From: Martyn White
Sent: 09 November 2011 12:51
To: Planningecons
Subject: RE: Planning Consultation on: BR/239/11/

APPLICATION NO: BR/239/11/

Registered: 16-SEP-11
Site Address: The Beach The Esplanade Bognor Regis PO21 1SY

Description of Works: Conversion of existing nightclub premises into two town houses & ten apartment flats

ELEVATION TO WATERLOO SQUARE AS EXISTING			
NORTH			
Scale	1:100 @ A3	Drawn By	ACB
Date	10/07/11	Checked	KEH
Drawing Number		4490 / 07

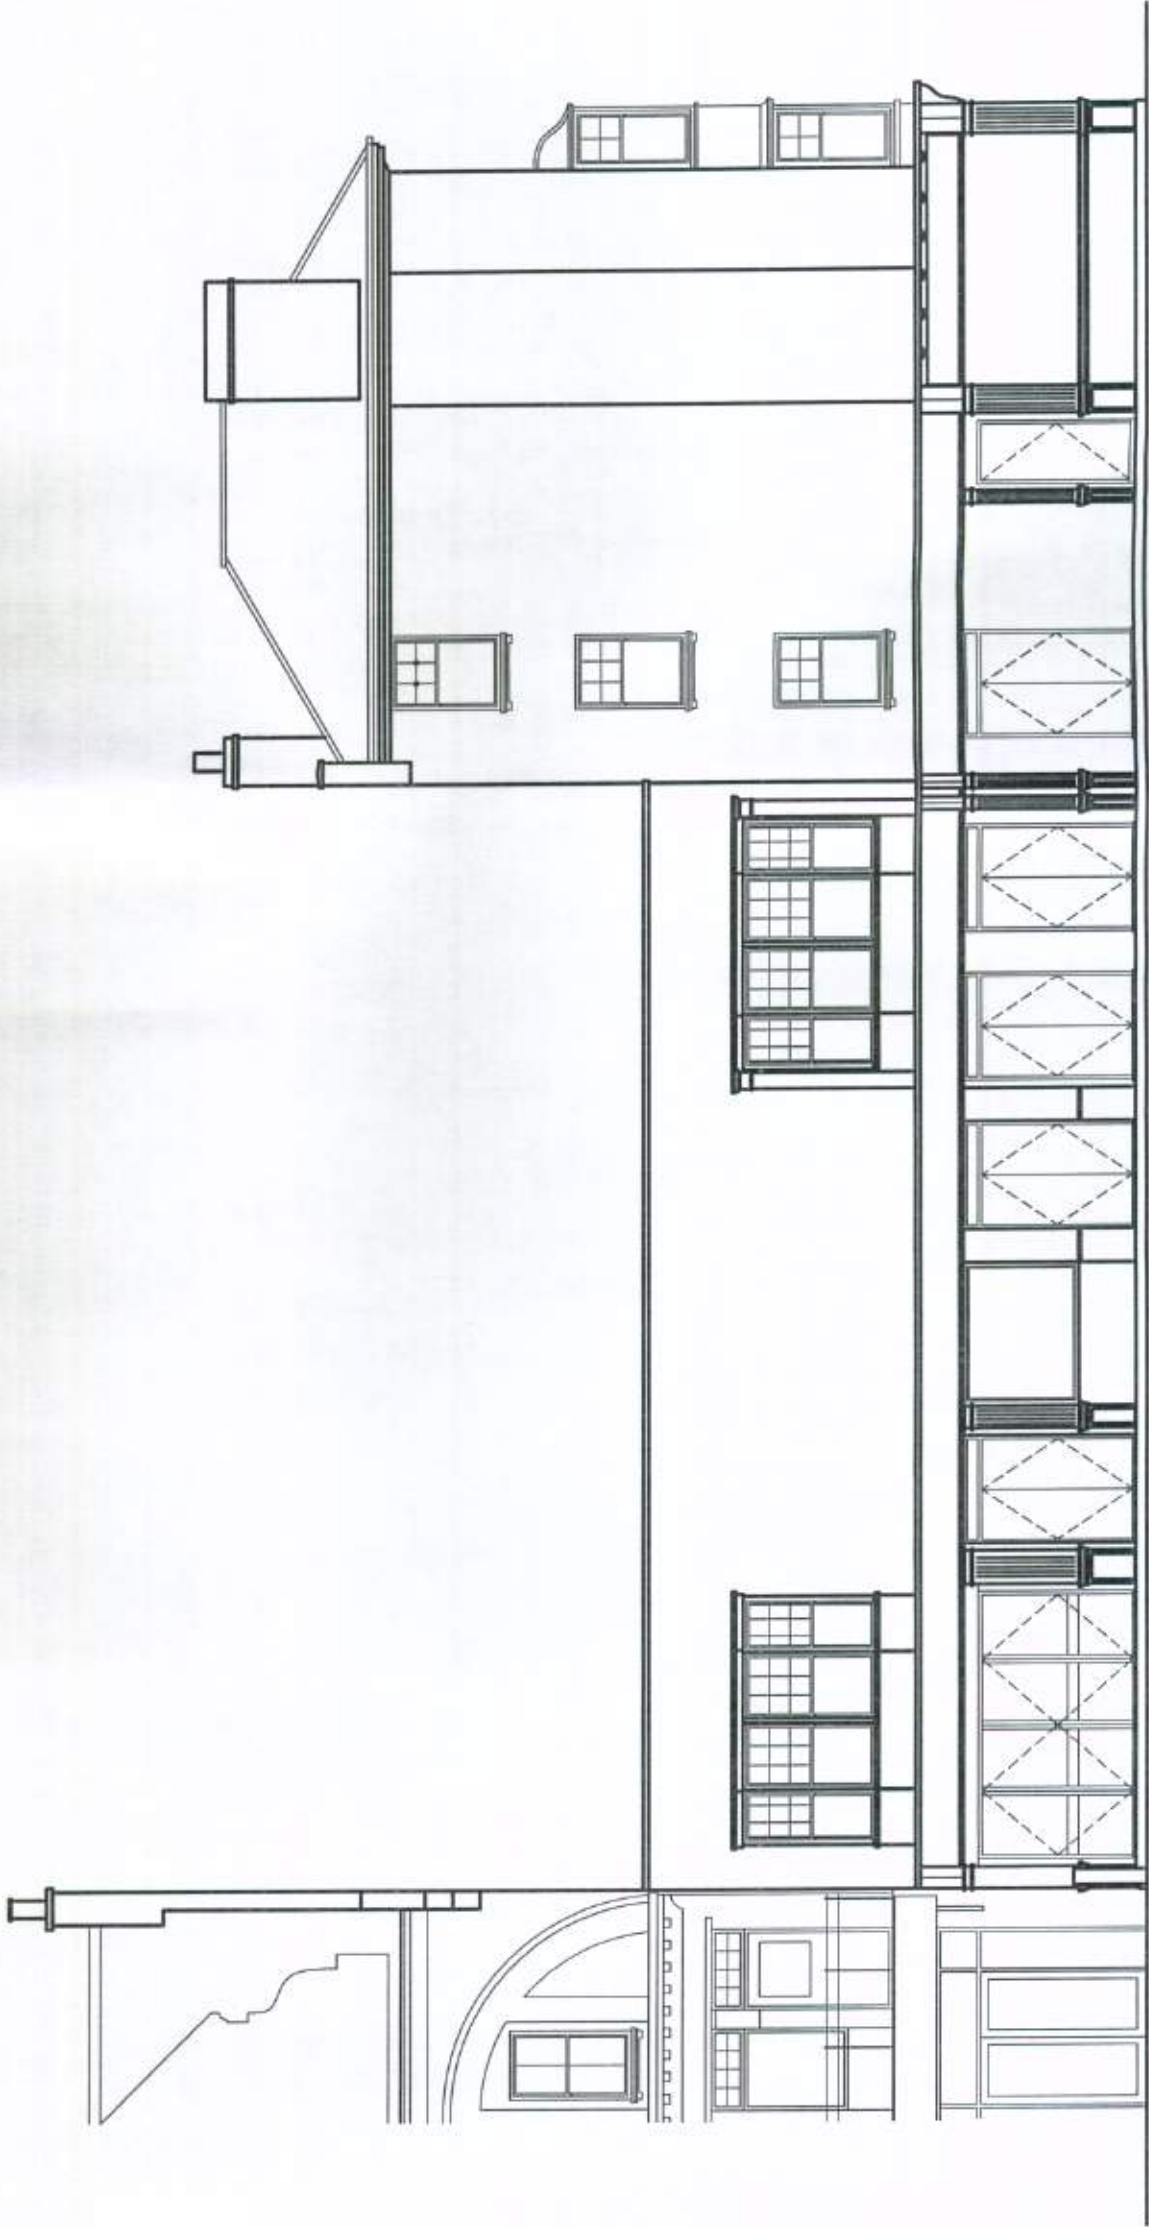
The proposal is for the redevelopment of the property in to 2 town houses and ten apartments. This involves a change of use and the redevelopment of a large section of the Waterloo Square elevation. Whilst the concept of the change of use and the redevelopment is acceptable, I have concerns over the use of what appears to be standard fenestration details to the French style doors and Juliet balconies to the Waterloo Square elevation. These windows/doors and balconies are considered to be of a style that is not in keeping with both the property and this part of the Conservation Area. It is suggested that a more appropriate style of window treatment be chosen instead which reflects the existing window style of the property (such as those on the Esplanade elevation).
